Melanie Gibbons MP

21 August 2020

RE: Moorebank Intermodal Precinct West: Stage 2 – MOD 1 – Building Height Increase (SSD-7709-Mod-1)

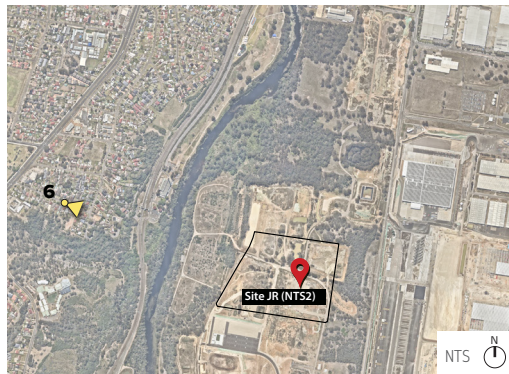
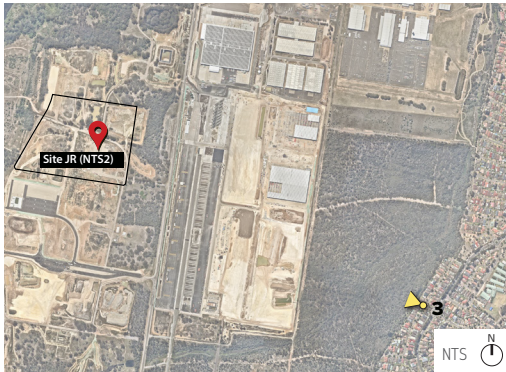
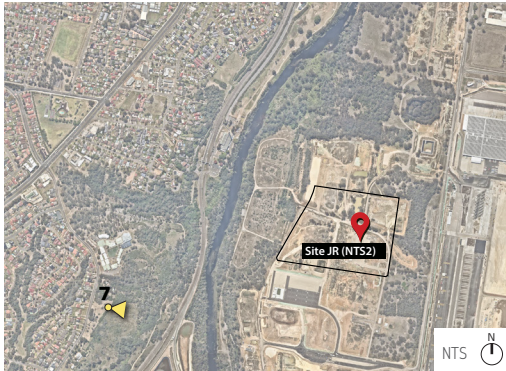
Furthermore, viewpoint 6 for warehouse JR (NTS2) provides an outline of the building which shows that it is covered by heavy vegetation. This same outline is not applied to warehouse JN (UNDC), which is the building that is much more visible to residents. Not providing the outline of the warehouse in the JN (UNDC) visual assessment, makes it difficult to see the true impact it would have on residents due to lighter digital render covered partially behind a single tree. Taking the photograph from a few steps further to the side would also show a much greater visual impact.
